**Our ref:** NO/2012/104499/01-L01  
**Your ref:** 3/2012/0942  
**Date:** 26 November 2012

**1,040 RESIDENTIAL DWELLINGS COMPRISING 728 MARKET HOMES, 312 AFFORDABLE HOMES, 156 FOR ELDERLY PEOPLE (I.E. OVER 55 YEARS OF AGE); 0.8HA TO BE RESERVED FOR RETIREMENT LIVING WITHIN THE TOTAL OF 1040 HOMES; 0.5 HA FOR LOCAL RETAIL, SERVICE AND COMMUNITY FACILITIES (CLASSES A1 TO A4, B1 AND D1); PUBLIC OPEN SPACE INCLUDING GREEN CORRIDORS AND AREAS FOR TREE PLANTING AND LANDSCAPING; IMPROVED (ROUNDAABOUT) JUNCTION BETWEEN PENDLE ROAD THE A59; NEW VEHICULAR, PEDESTRIAN AND CYCLE ACCESSES ONTO PENDLE ROAD AND LITTLEMOOR; NEW PEDESTRIAN AND CYCLE ACCESSES ONTO WORSTON OLD ROAD; TEMPORARY VEHICULAR ACCESS ONTO WORSTON OLD ROAD; NEW PEDESTRIAN AND CYCLE ACCESS FROM THE END OF SHAYS DRIVE; ROADS, SEWERS, FOOTPATHS, CYCLEWAYS, SERVICES AND INFRASTRUCTURE INCLUDING A SUSTAINABLE URBAN DRAINAGE SYSTEM, NEW SERVICES SUCH AS GAS, ELECTRICITY, WATER AND TELECOMMUNICATIONS  
LAND AT HIGHER STANDEN FARM AND PART LITTLEMOOR FARM,

CLITHEROE**

The Illustrative Masterplan

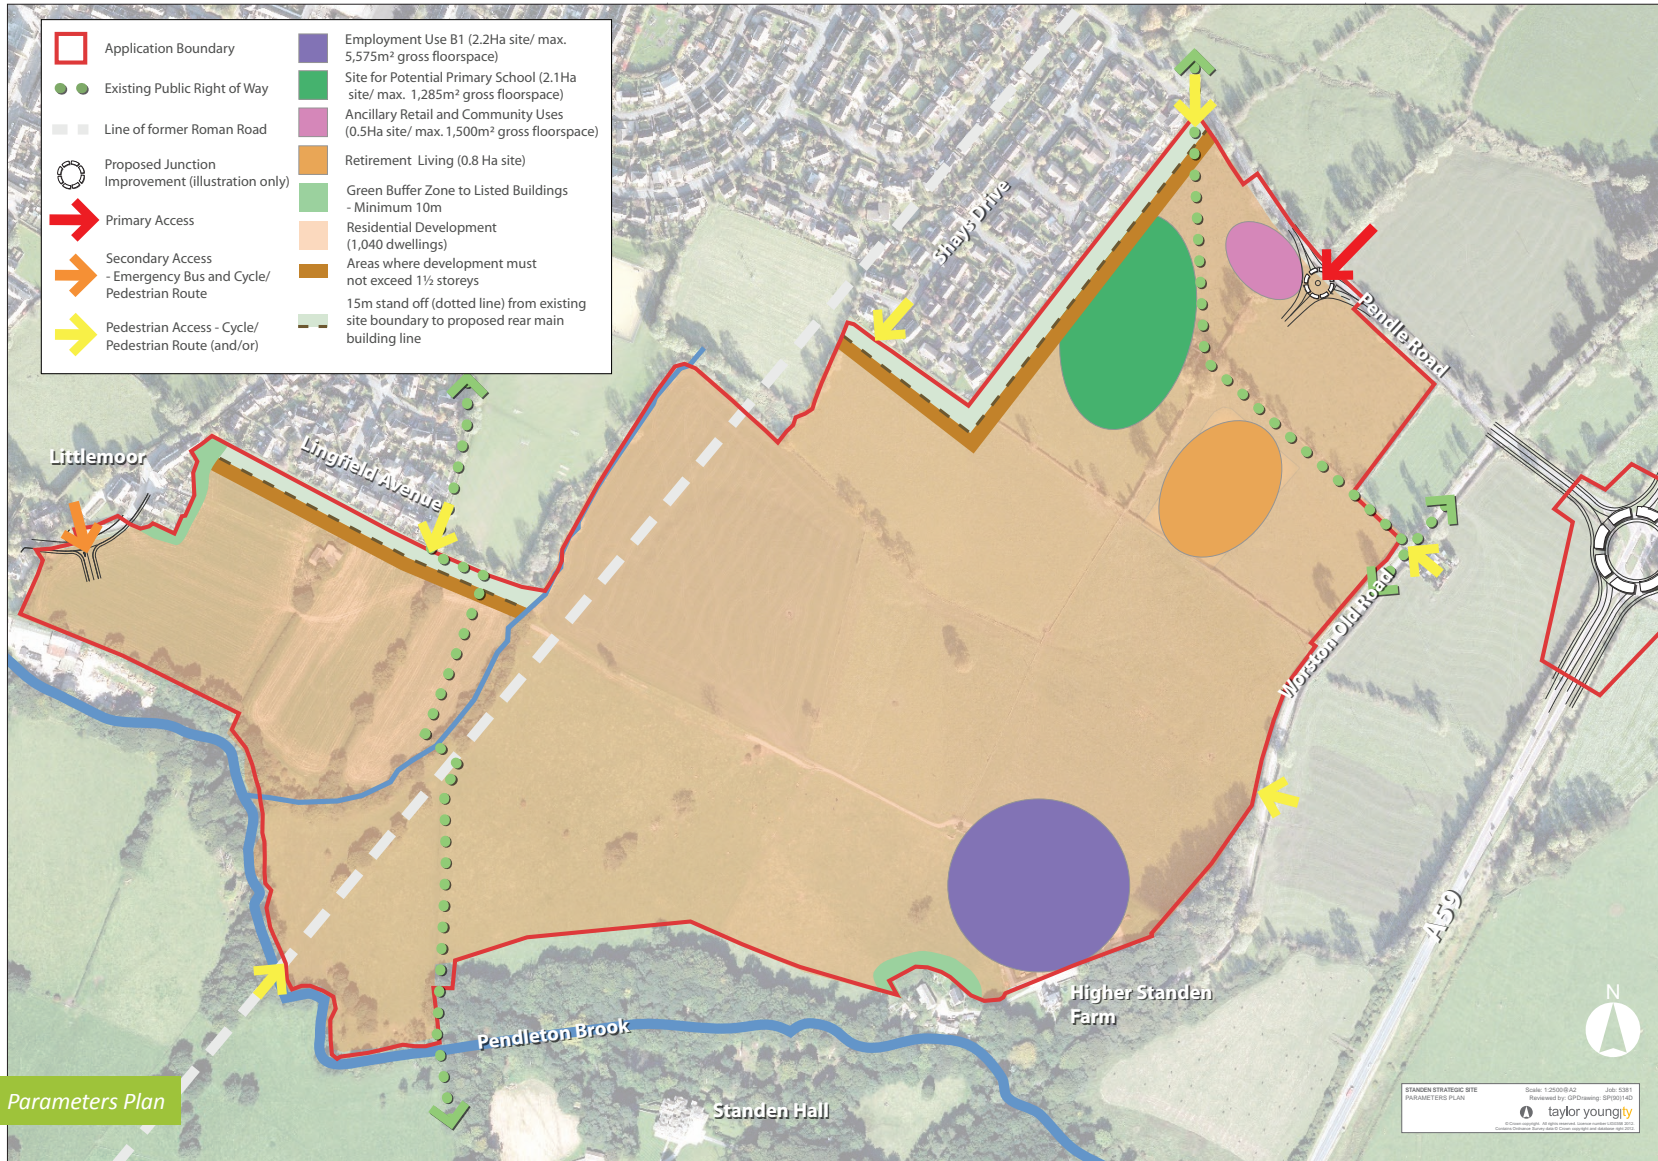
The illustrative masterplan shows a proposed pond/SUDS attenuation feature within the proposed B1 Employment area. We would recommend that this attenuation

feature is incorporated in to the Green Corridor/Open Space area. This feature would be better suited in this location than within an employment area.
